Consultee Comment for planning application 19/01740/HYBRID

Application Number	19/01740/HYBRID
Location	Land Adj To Promised Land Farm Wendlebury Road Chesterton
Proposal	'Hybrid' planning application comprising: - Outline planning permission (all matters reserved except for access) for up to 23,400sq.m of B1 development (Use Classes B1a and/or B1b and/or B1c); highway works (including provision of a new roundabout at the junction between Vendee Drive and Wendlebury Road); creation of a wetland and landscaped areas and associated infrastructure works. - Full planning permission for a health and racquets club, associated access and car parking, outdoor tennis courts, air dome, outdoor swimming pool, spa garden and terrace, and associated landscaping.
Case Officer	Clare O'Hanlon
Organisation	Clerk to Chesterton PC
Name	Jackie Williams
Address	Chesterton Community Centre 2 Geminus Road Chesterton Bicester OX26 1BJ
Type of Comment	Comment
Type	
Comments	See Attached document.

CHESTERTON PARISH COUNCIL'S RESPONSE TO CATALYST BICESTER
APPLICATIONS: 19/01746/OUT & 19/01740/HYBRID

Figure 2 Walking catchment (based on currently available routes)

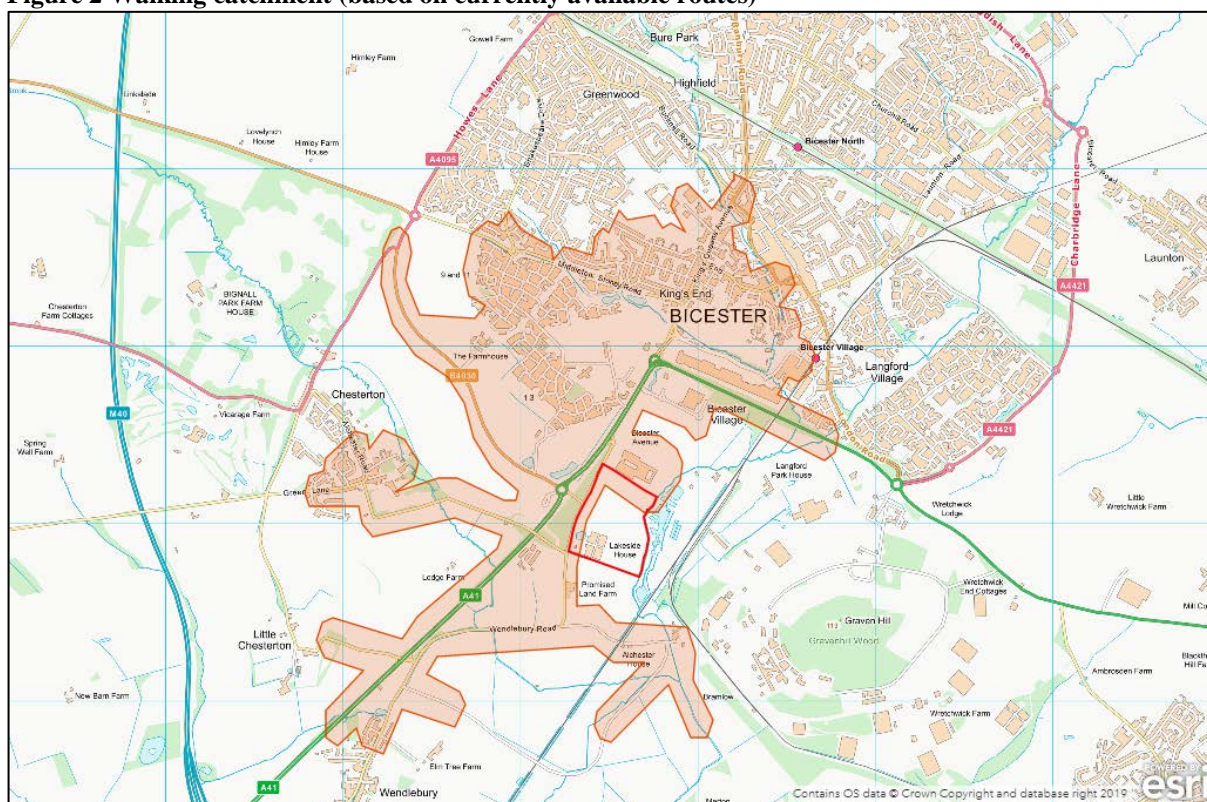
The walking catchment is a good idea in principle, but will it materialise in practice? Will measures really be implemented to encourage and monitor this aspiration?

Figure 3 5km Cycling catchment (based on existing routes)

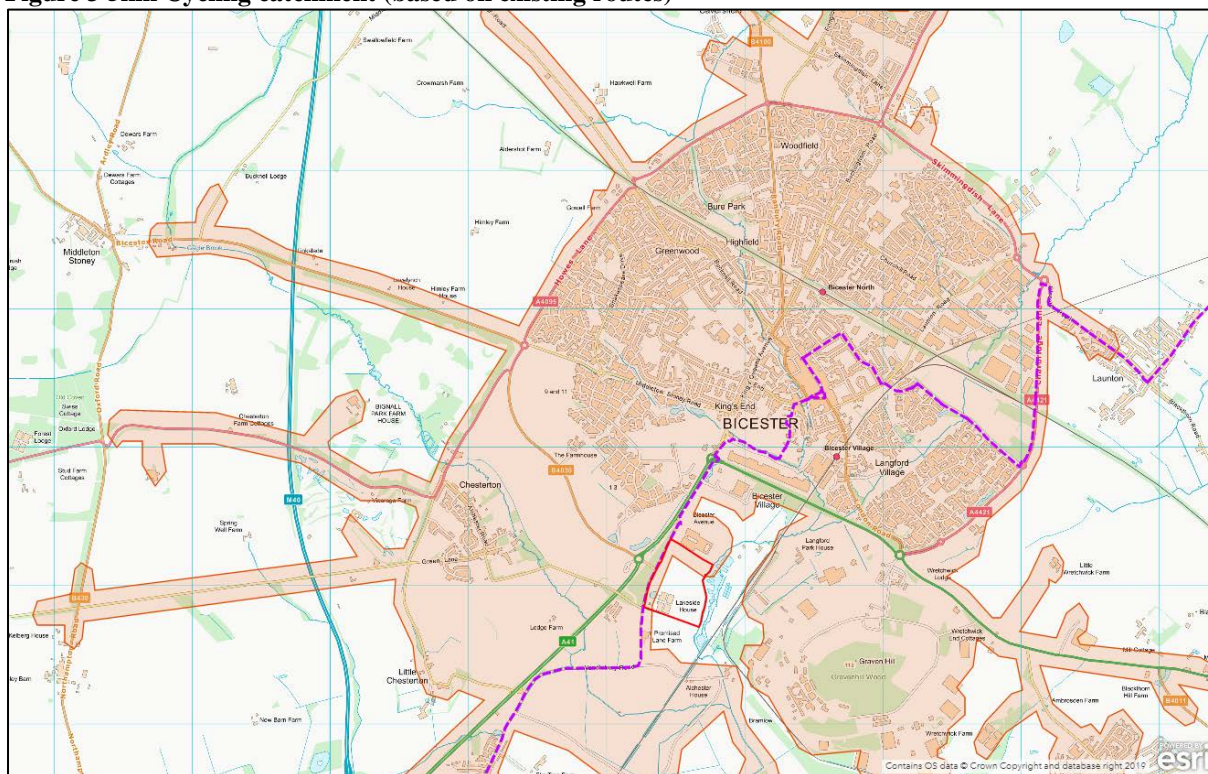
The cycling routes are interesting, including the A4095 towards Chesterton. However, the speed limit for most of this section is 60pmh and can be very dangerous for cyclists where no cycle track is provided yet would be needed should cycle traffic increase.

Figure 8.3 – New Roundabout Junction

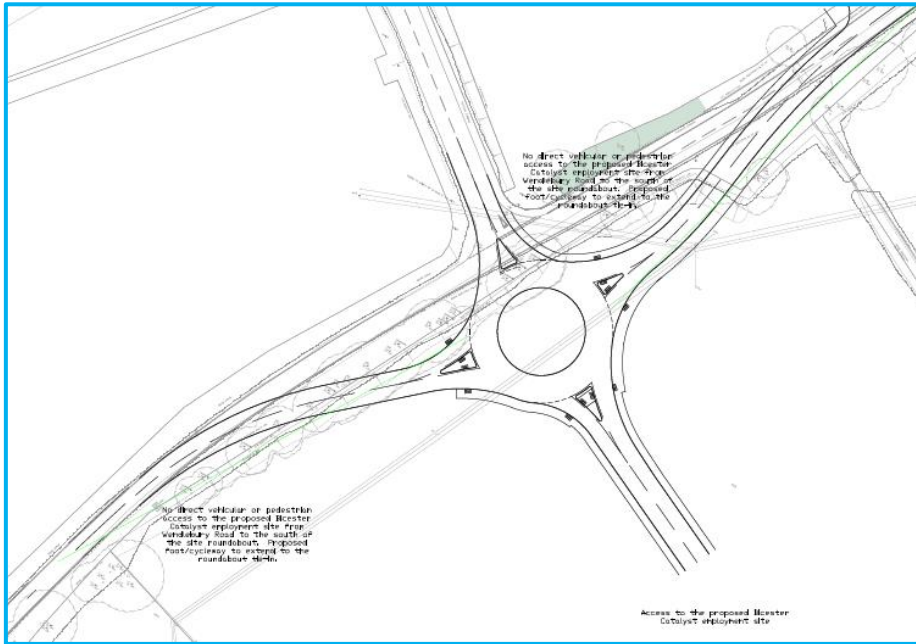
b. Devpt of Site Point 4: Inclusive new roundabout junction on Wendlebury Road and Internal Access Roads. Potentially dangerous if access from the bridge onto Wendlebury Road is not widened for better visual splay. Potential need for traffic lights on this roundabout as access traffic will not need to stop and Chesterton traffic will not be able to get onto road. Will the proximity of this proposed new roundabout to the existing Vendee Drive roundabout not impact on traffic on the A41?
